Consultation Response from KC, Conservation & Design
2022/93248 Piazza Centre, Princess Alexandra Walk, Huddersfield, HD1 2RS

Demolition of existing Piazza shopping centre; part removal of Queensgate Market; demolition/retention of service tunnels; redevelopment of the site to form new public realm space (including public park and gardens, play areas, public square/outdoor event space); refurbishment and change of use of existing Queensgate Market Hall into food hall (Use Class E (b) sale of food and drink for consumption, mostly, on the premises); refurbishment and extension of existing library and art gallery building to form museum (Use Class F.1); change of use of part existing market hall building and extension to form public library (Use Class F.1); erection of indoor event venue incorporating multi-storey car park below (Sui-Generis); erection of public gallery building (Class F.1); associated infrastructure on land and buildings at Queensgate Market, Huddersfield Library and Art Gallery, and Piazza (and The Shambles) Shopping Centre (part Listed Building/part within a Conservation Area)

Date Responded: 20.2.2023
Responding Officer: Sue Brooks
Responding Ref:

SOUTH FACADE STUDY

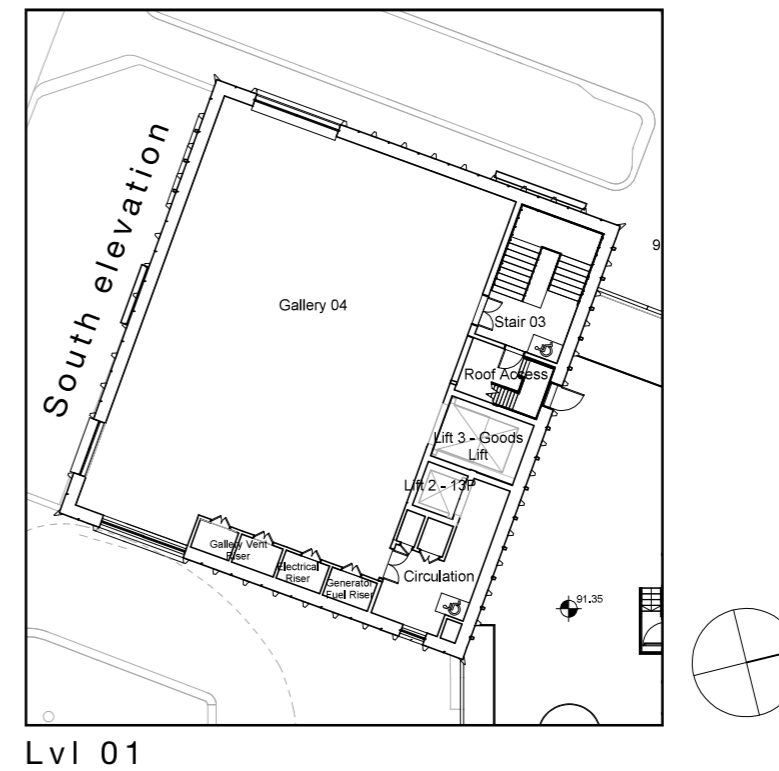
A taller gallery building is proposed on the corner of Queen Street and Queensgate. Having initially considered that this building had the potential to dominate the corner, the design has been further amended to break up the massing by introducing more fenestration facing the proposed steps. Colour and texture of final materials will also play an important role in providing a coherent element to the development as a whole. As the building is set back from the corner of Queen Street its impact on the setting of the listed terrace on the east side of Queen Street is kept to a minimum, with a large tree on the junction retained to soften and partially obscure the east elevation.

VENUE - ENVELOPE STUDIES

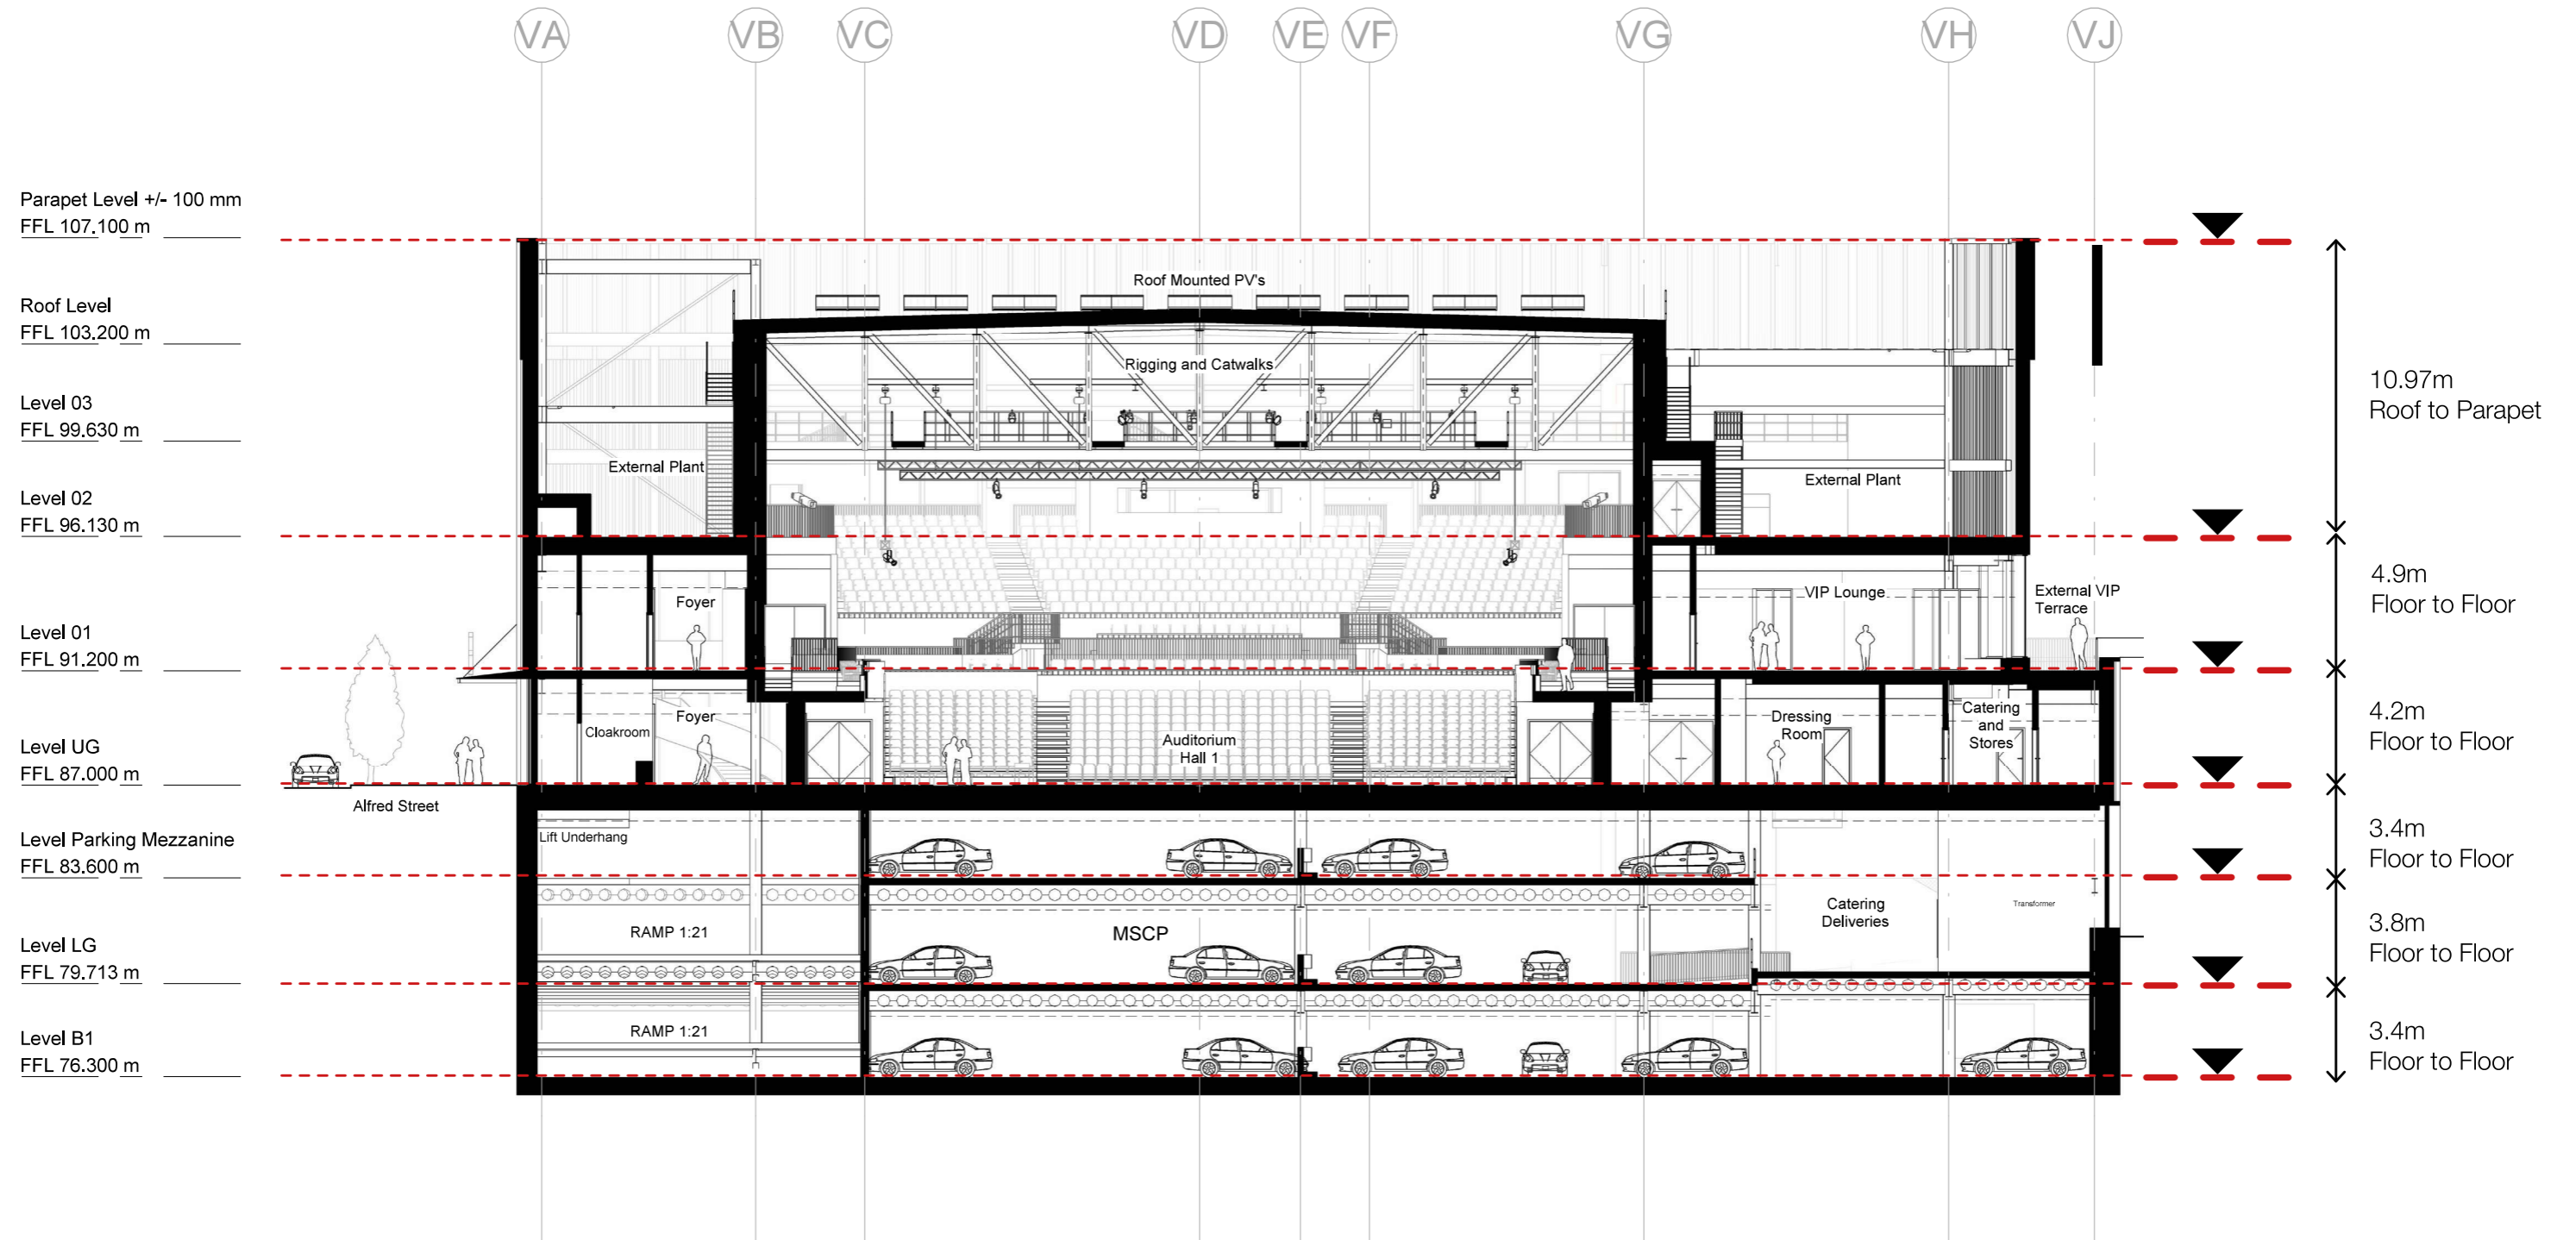
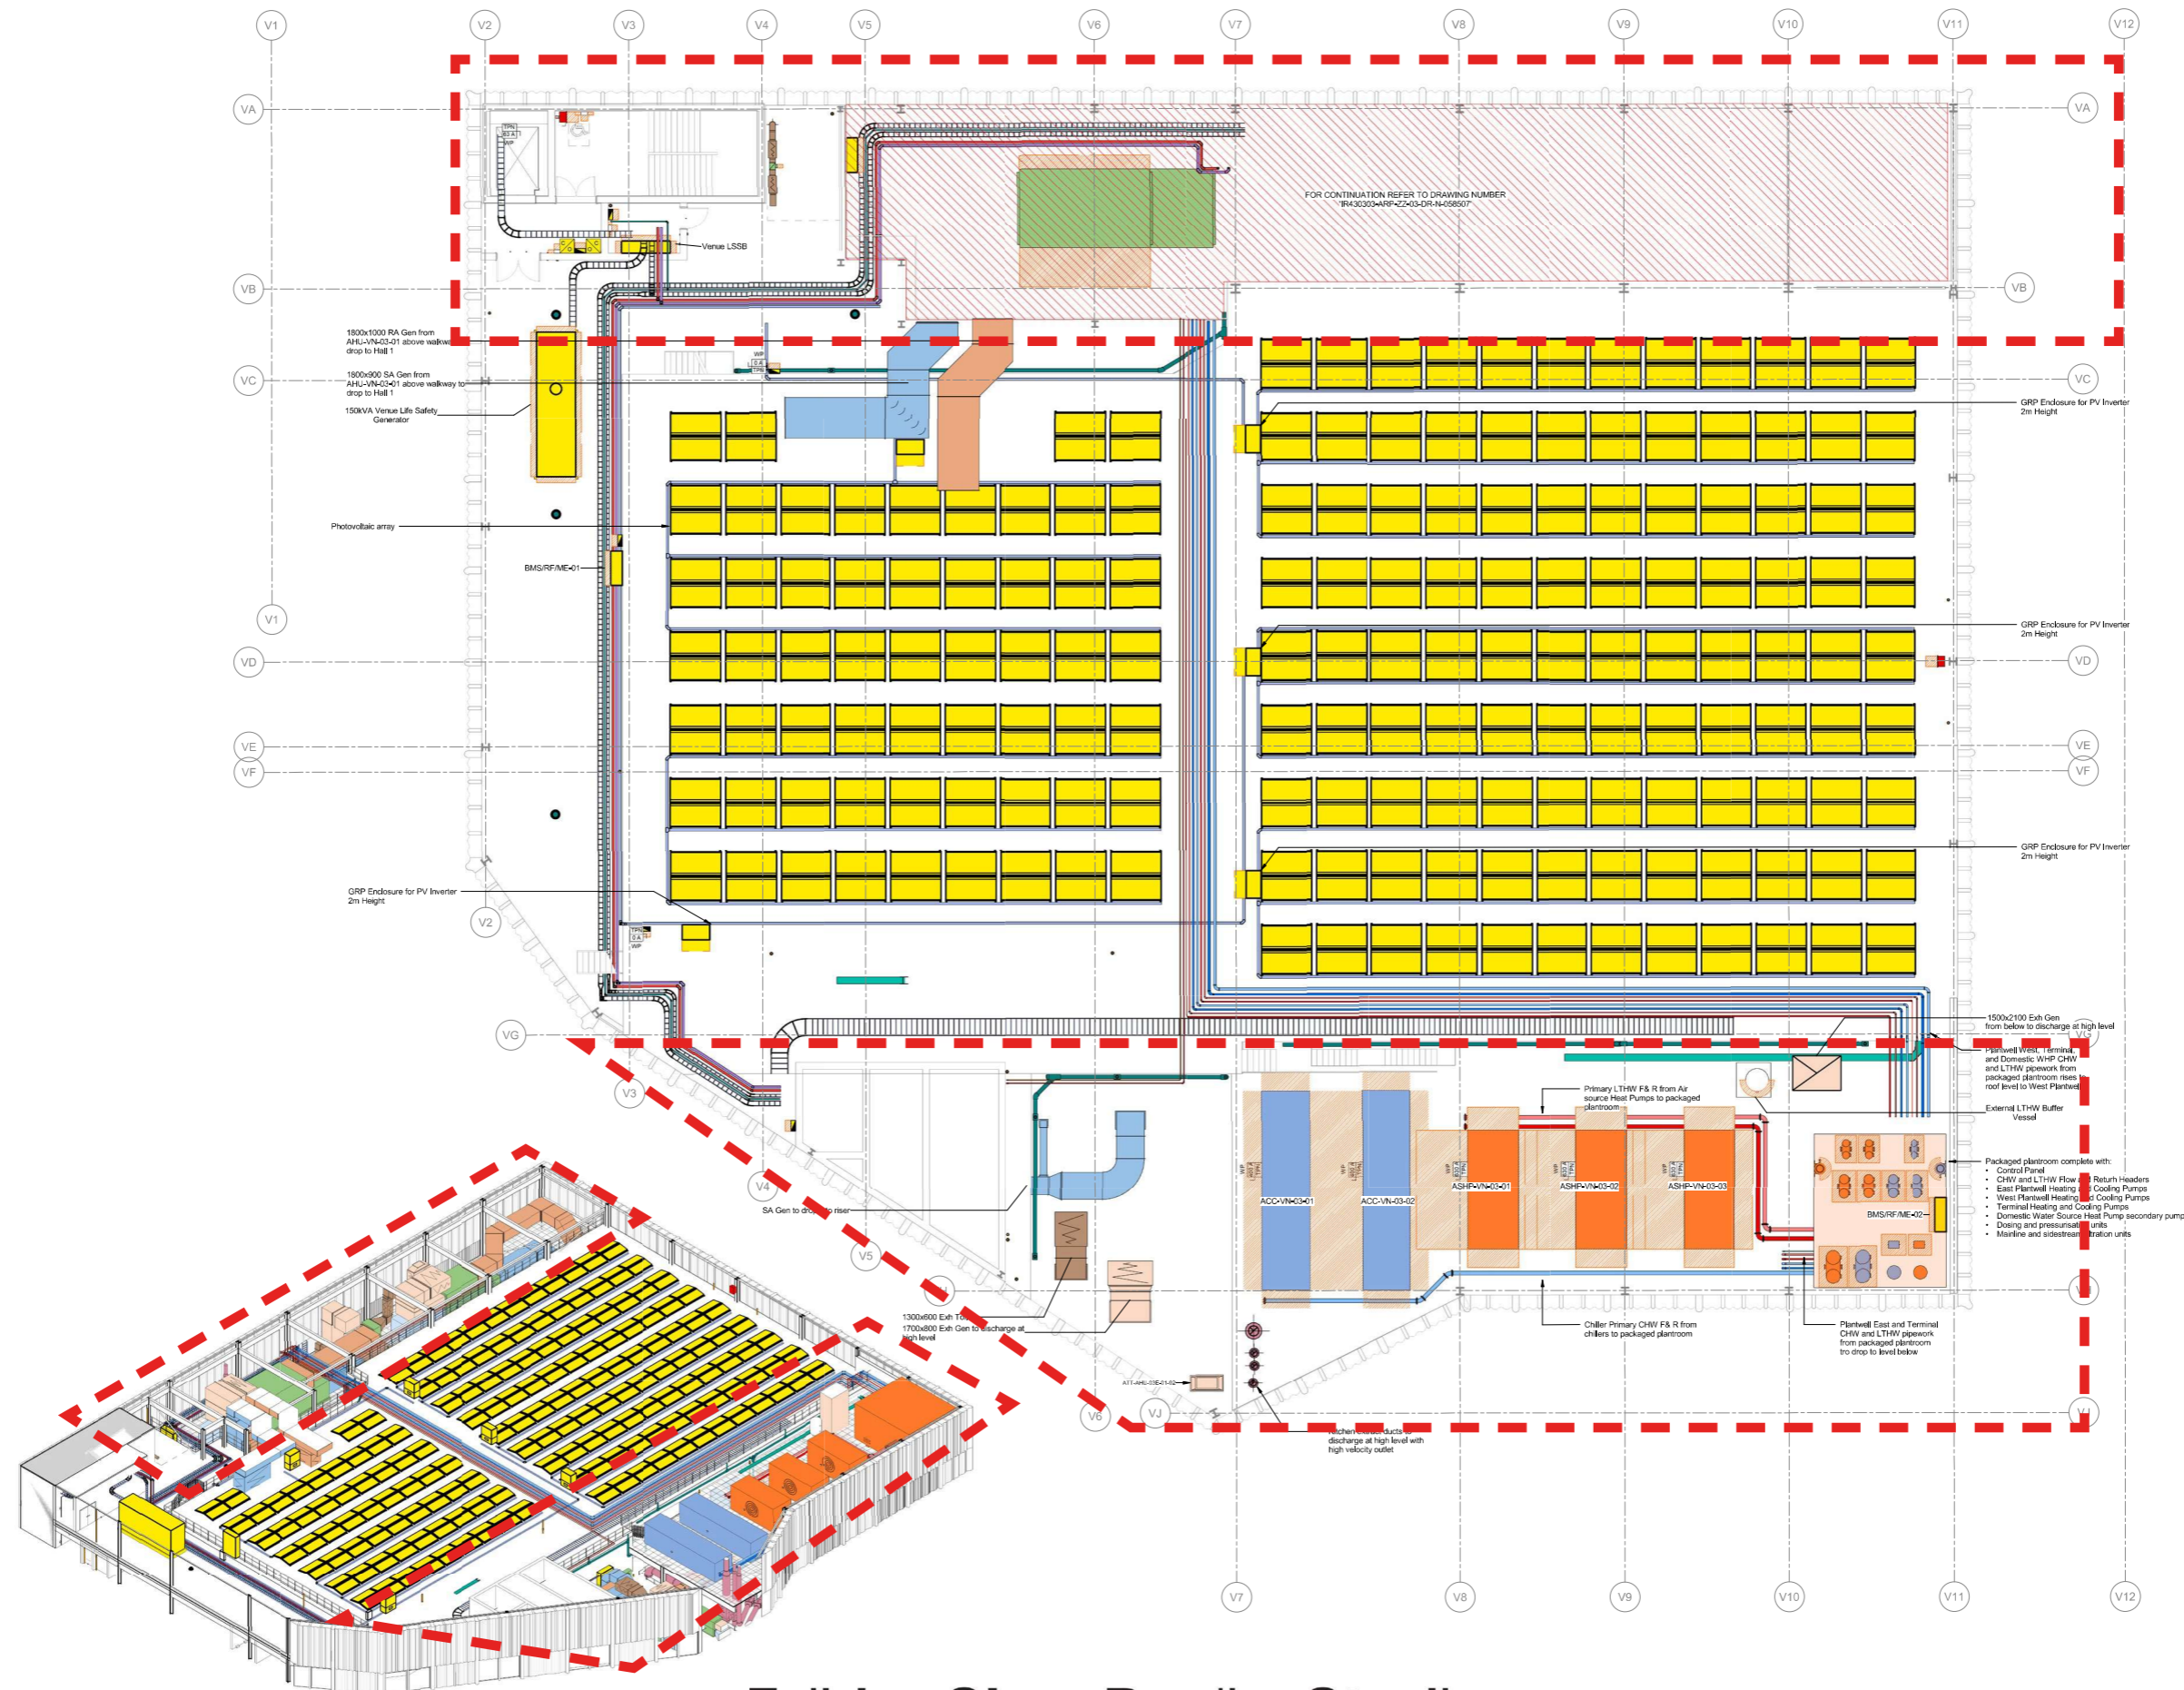
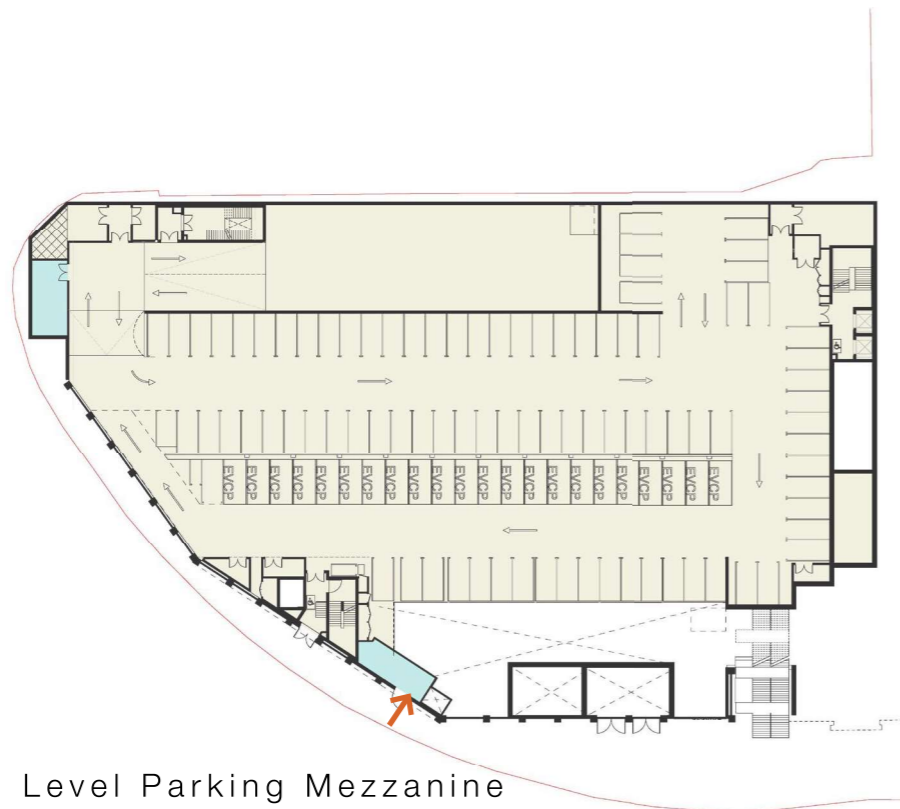
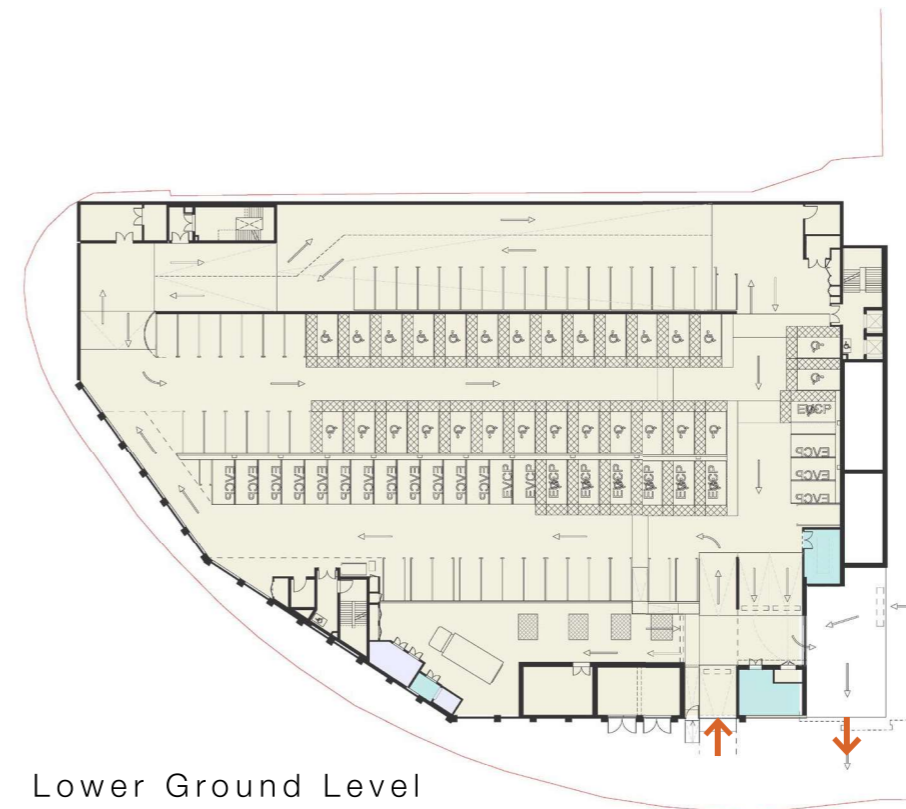
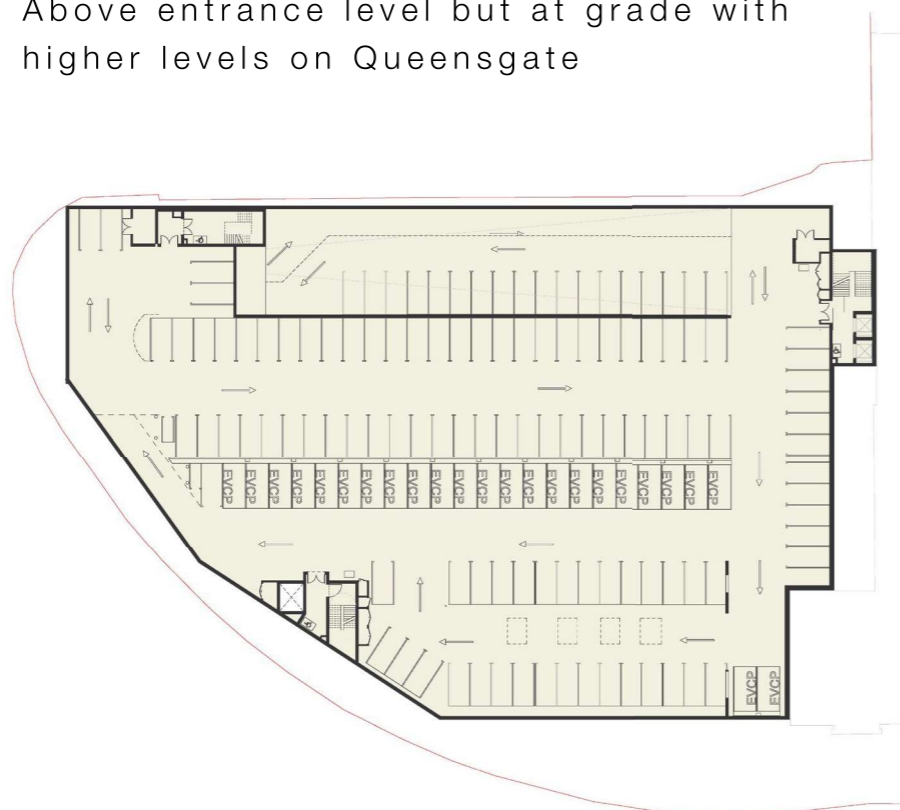
Initial queries regarding the scale of the building and the vertical emphasis of the external elevations, particularly facing Queensgate, to minimise any conflict with the horizontal emphasis of Queensgate Market and its parabolic mushrooms have been further explored and overcome resulting in some minor changes being made to the east elevation, with horizontal detailing following the line of the

market building, glazing and external finishes at ring road level creating a live frontage which reduces the visual massing.
